Appendix B

Department	Reviewer	Cycle	Comment #	Comment	Drawing/Document	Response
City of Ottawa - Planning	Kersten Nitsche	2	1	The Site Plan and Landscape Plan do not match. The Site Plan shows two vehicular lay-by areas on Miwaté Private to the south of Block 204. On the Site Plan, they appear to conflict with a planter curb and concrete sitting wall (north side of Miwaté) and pedestrian light post (south side of Miwaté).	N/A (General Comment)	Please refer to updated drawing set - the vehicular lay-by illustrated on the Site Plan has been removed.
City of Ottawa - Planning	Kersten Nitsche	2	2	Please provide a Site Plan and Landscape Plan that does not include the vehicle pathways and turning movements as the linework makes these plans difficult to read. Please shift the vehicle movements to a stand-alone plan that minimizes other linework (e.g., landscaping hatching, etc.) so that those movements are clear and easy to read.	A100 - Site Plan L1.1, L1.2 - Landscape Plan Ground Floor	See Architectural Site Plan A101 where turning radii and vehicle pathway linework have been removed. Linework has also been removed from Landscape plans L1.1 and L1.2.

From: [Mottalib, Abdul](#)
To: [A

City of Ottawa Project #: D07-12-22-0071 City of Ottawa Plan #: 18749

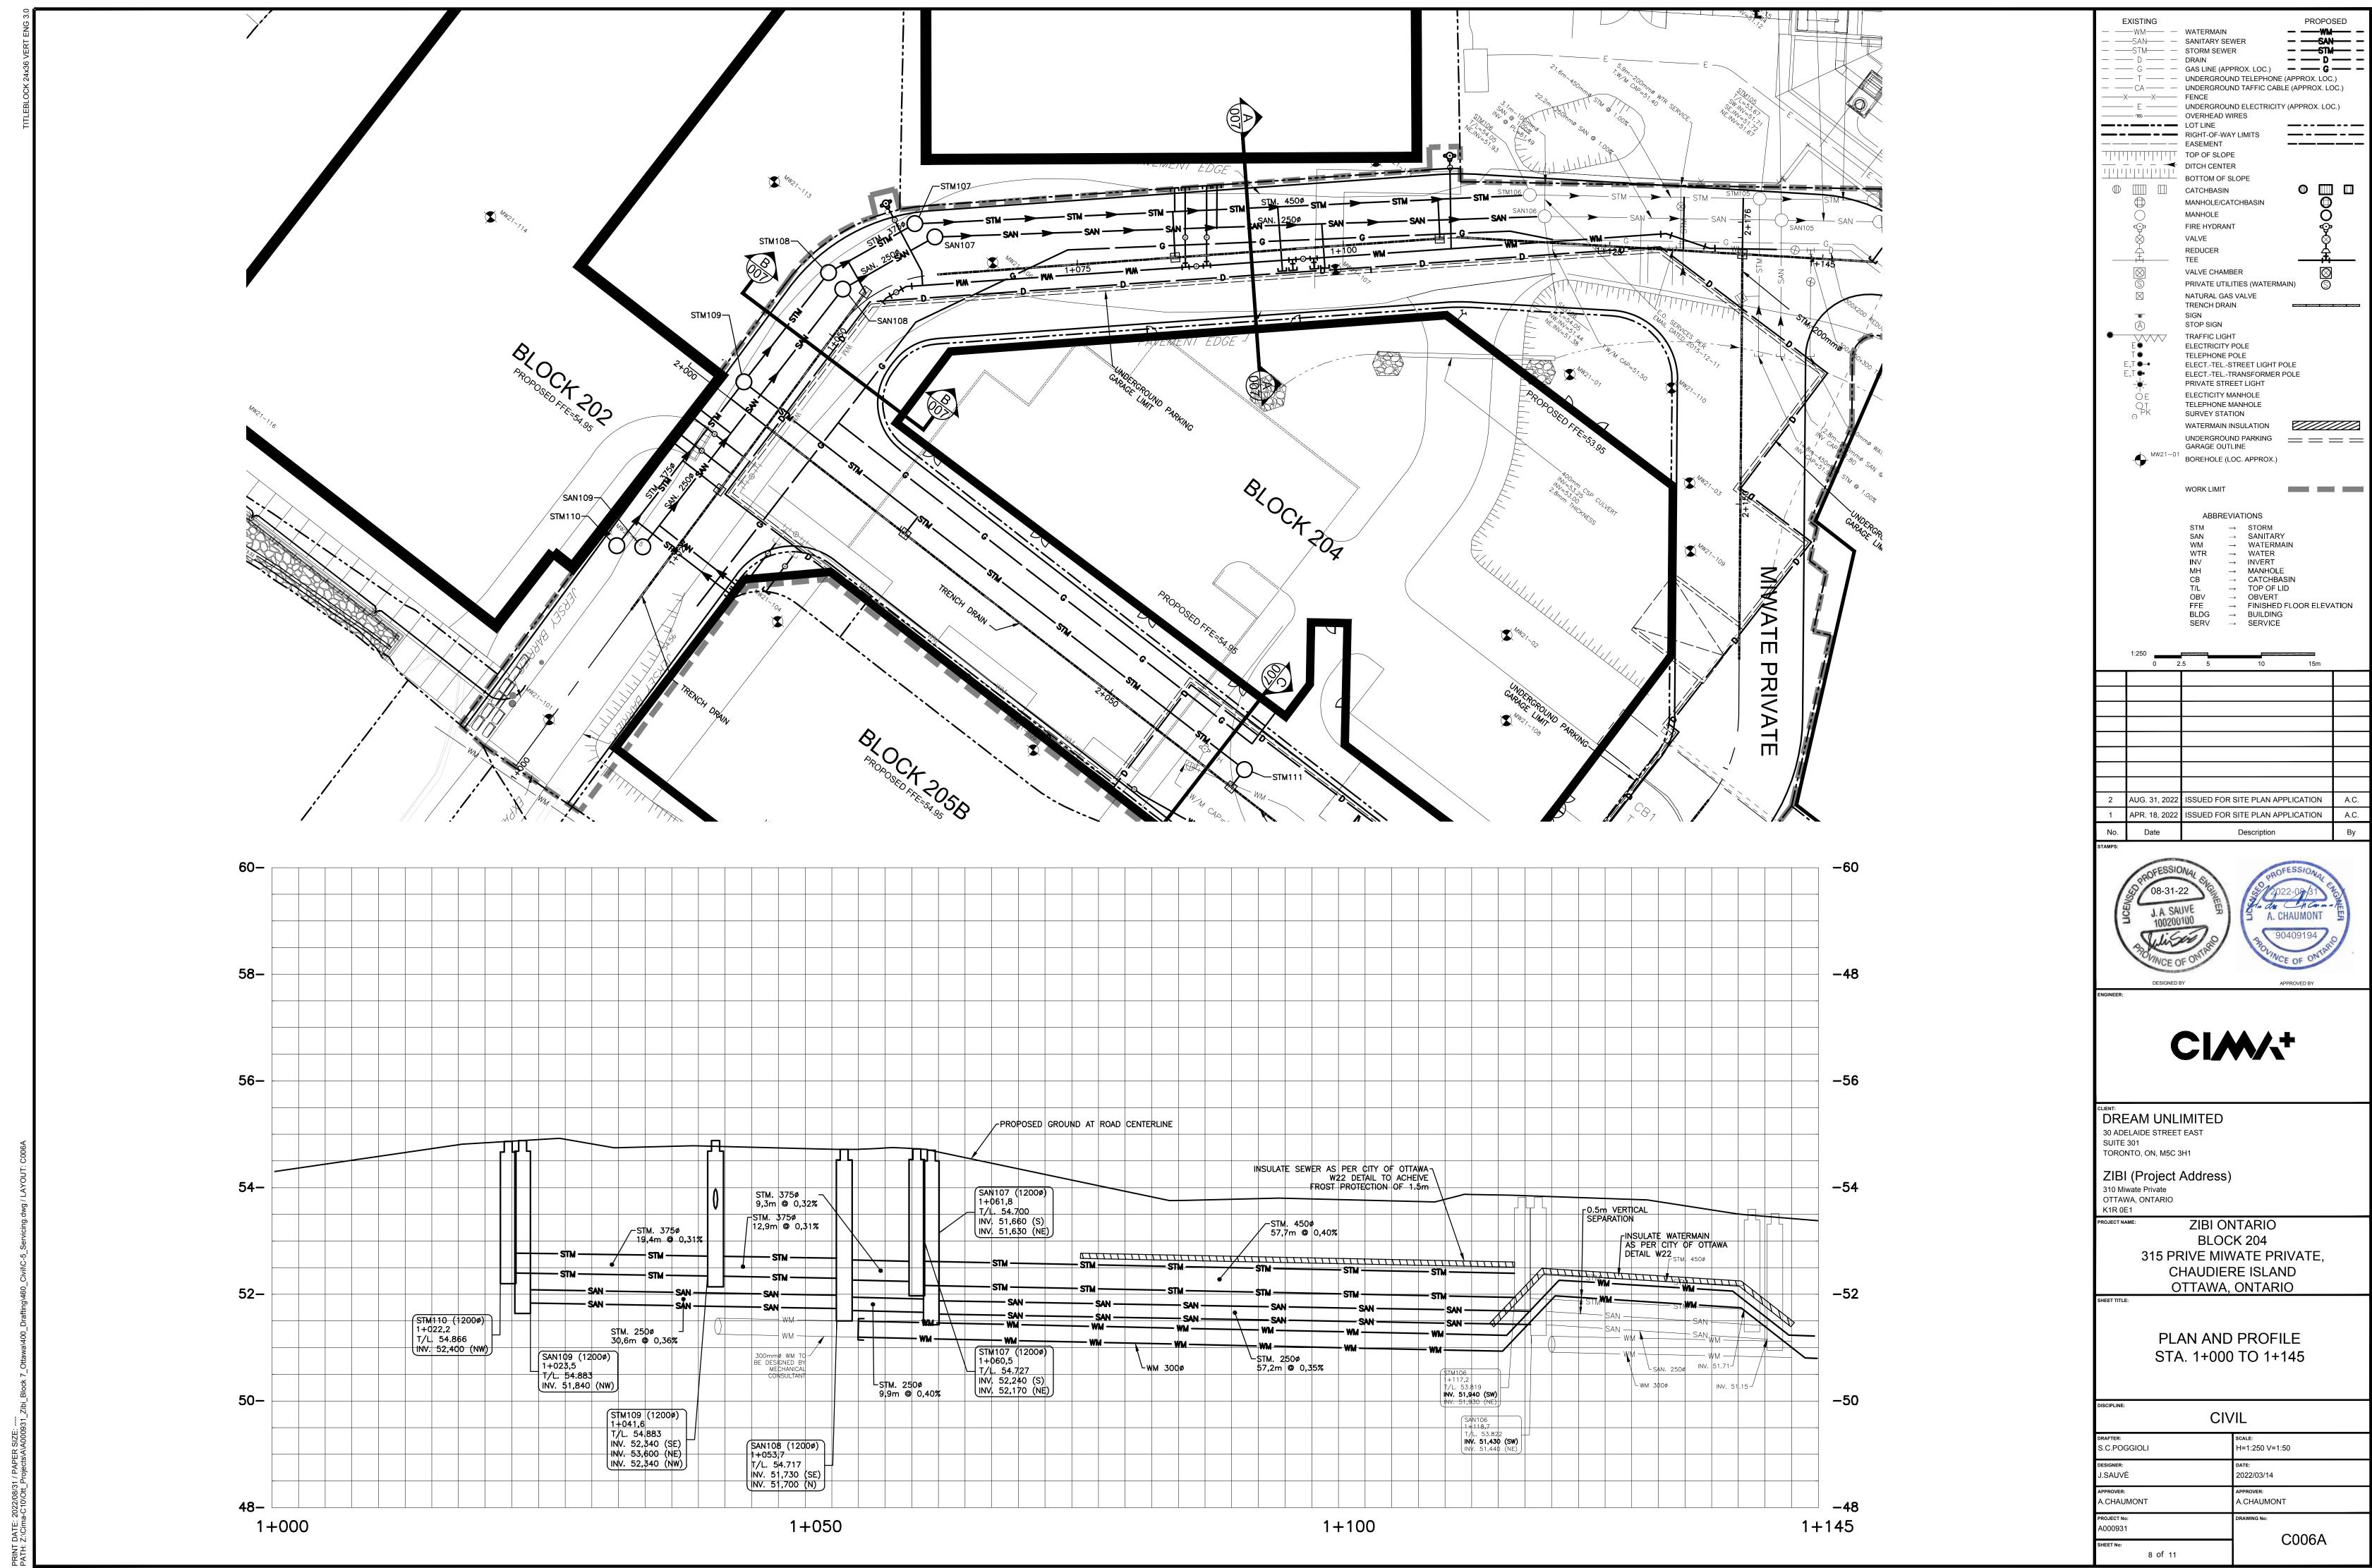
City of Ottawa - Infrastructure	Abdul Mottalib	2	15	Could you please include note 1 from the attached EC plan in your plan C003?	Site Servicing Layout: ZIBI Ontario-Block 204, Dwg no. C005B, Revision 2 dated August 31, 2022, prepared by CIMA+	Note added as requested to plan C003. See Note 1.1.
City of Ottawa - Infrastructure	Abdul Mottalib	(1) 2	(29) 7	(Cycle 1 - Previous) As the ZIBI site will have perimeter meters at the entrance, please put specific notes regarding this on the plan as before. (Cycle 2) please note the requested above note is very important and required for the servicing plan specifically for issuing the CWNL, please add this note on the servicing plan in addition to the notes that was added in the "Notes Plan."	Site Servicing Layout, (interim): ZIBI Ontario-Block 204, Dwg no. C005A, Revision 1 dated April 18, 2022, prepared by CIMA+	The note 2.20 in the Services section - Drawing C002 -Notes Plan was copied on C0005B - Site Servicing Layout drawing to address this concern.
